Project #: 100871dp Application #: 11DRB-70212
Project Name: Del Norte Plaza
Agent: Modulus Architects Inc. Phone #:

**CITY OF ALBUQUERQUE
PLANNING DEPARTMENT
December 7, 2011
DRB Comments**

RE: Tract 4, Del Norte Plaza

Project# 1008766

SHEET TITLE
 SITE PLAN FOR BUILDING PERMIT

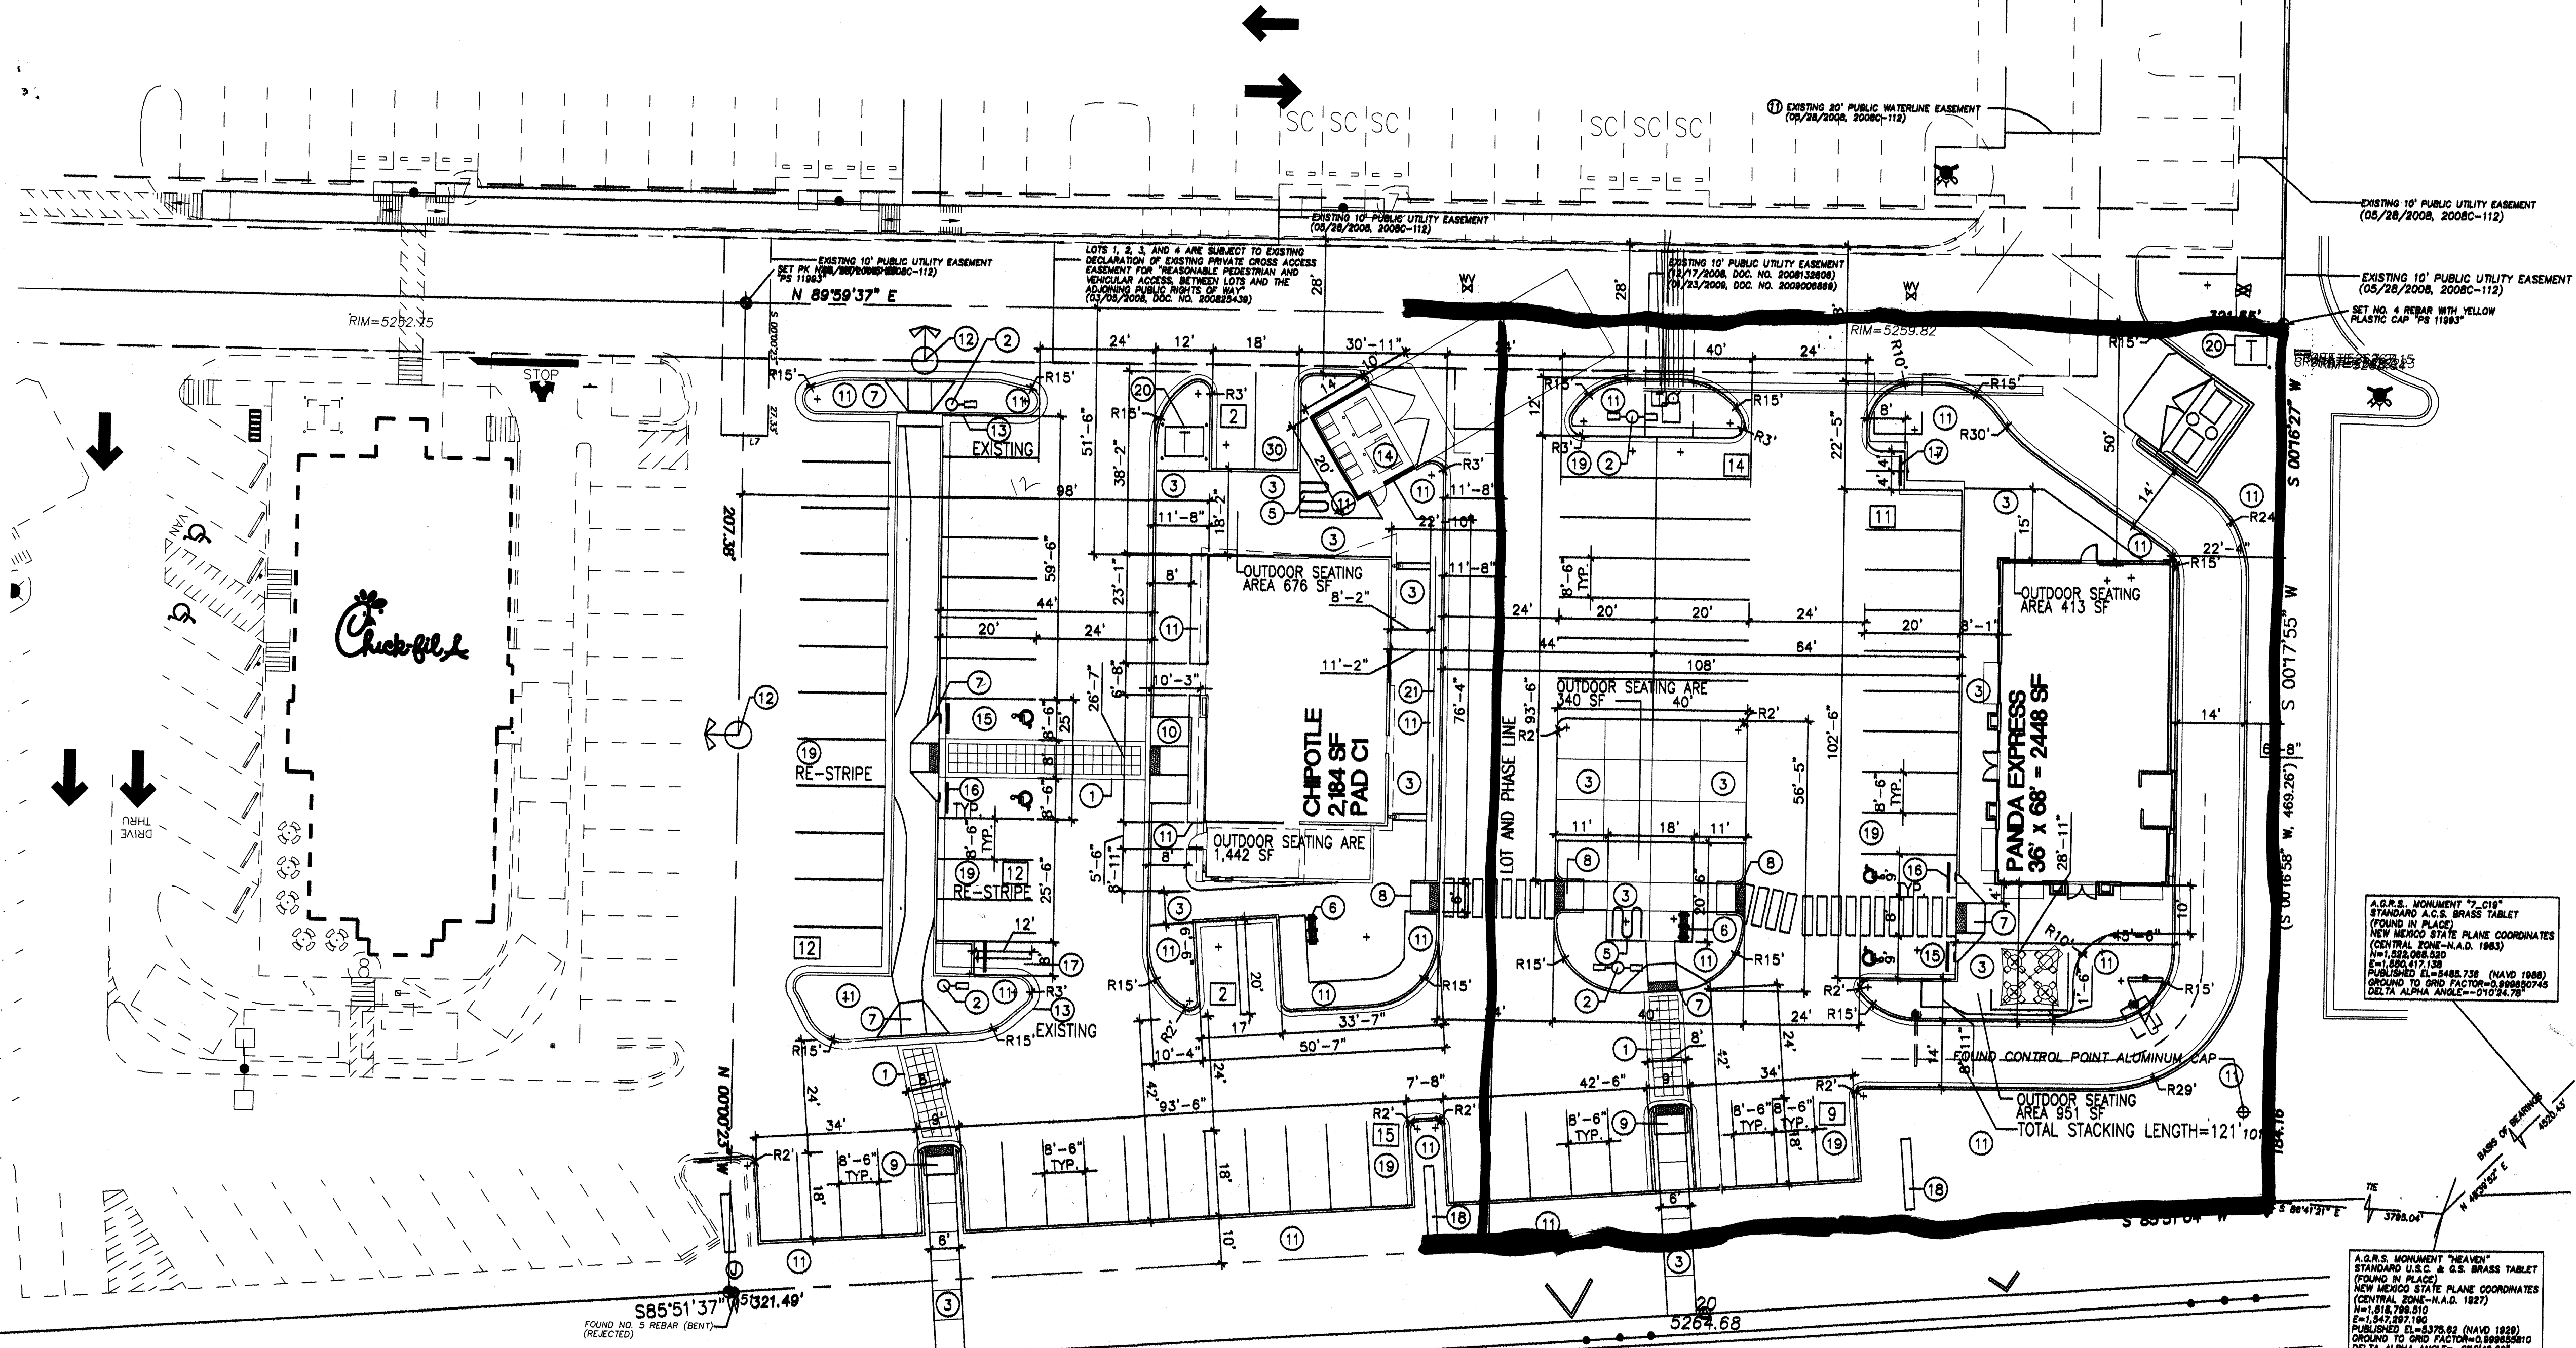
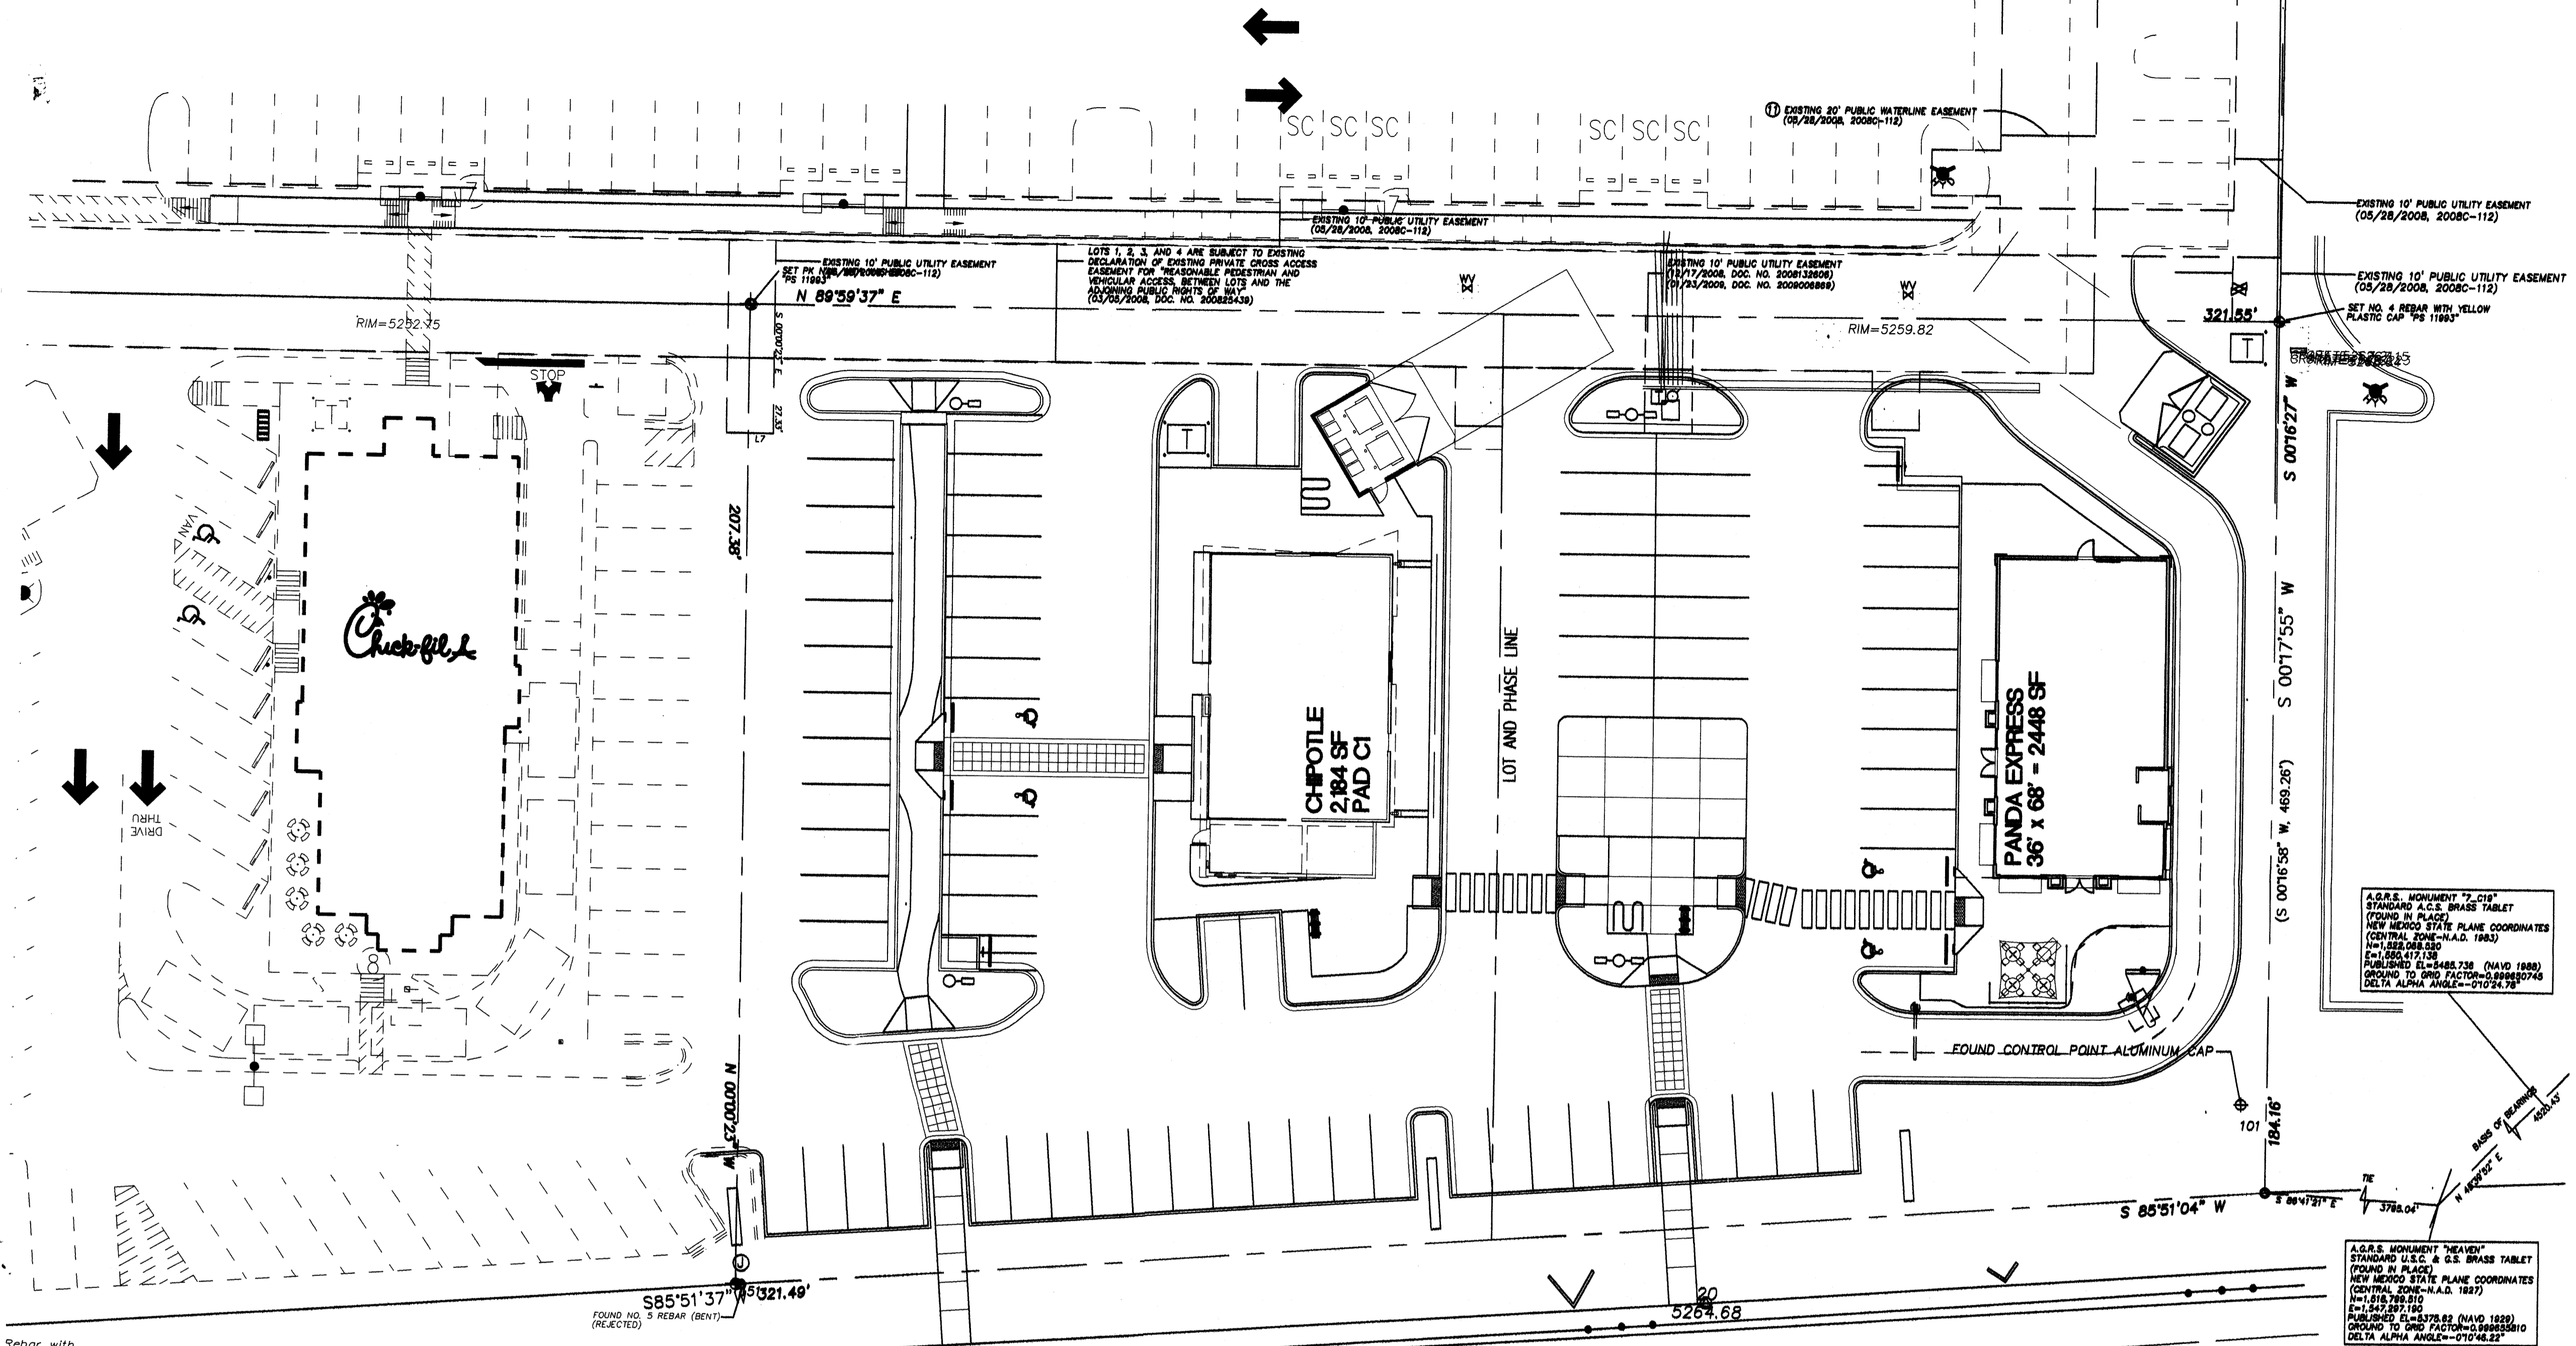
- Define all easements and provide recording information.
- Call out the width of all sidewalk.
- Define all radii.
- The previously approved site plan showed pedestrian interconnectivity between Pad E and Pad C. However, the proposed changes appear to remove the ADA pathway from Pad E to the roadway. This connection must be maintained.

- Clearly define the location of the delivery window for the proposed Panda Express. The stacking length defined appears to be longer than shown.
- For drive throughs, please note that "Minimum lane widths are 12 feet minimum with a 25-foot minimum radius (inside edge) for all turns. (A 15-foot radius can be used with an increase in lane width to 14 feet)." See the *Development Process Manual*, Chapter 23, Section 7, Part E for further information.

Motorcycle parking does not meet code requirements: two for each building, and must be visible from entrance.

Pedestrian connection from Paseo del Norte path to the western parking aisle must be provided for Pad E per approved site plan. This and the pedestrian connection between buildings needs to be textured concrete also.

- The access easement referred to on the plan has a recorded date of 03-05-2008; however, the *Common Operation and Reciprocal Easement Agreement for Pacific Paseo* has a recorded date of 05-20-2009. Please revise.
- The access easement shown on the site plan does not match the pathway defined as the “Circulation Drive” within the *Common Operation and Reciprocal Easement Agreement for Pacific Paseo* (recorded 05-20-2009).
- Call out the width of all sidewalk.
- The vicinity map does not clearly indicate the site location.
- Provide appropriate “Do Not Enter” signing and striping at the exit of the drive through.
- Detail 12 (Sheet A1.1) does not define the maximum slope of the ramp.
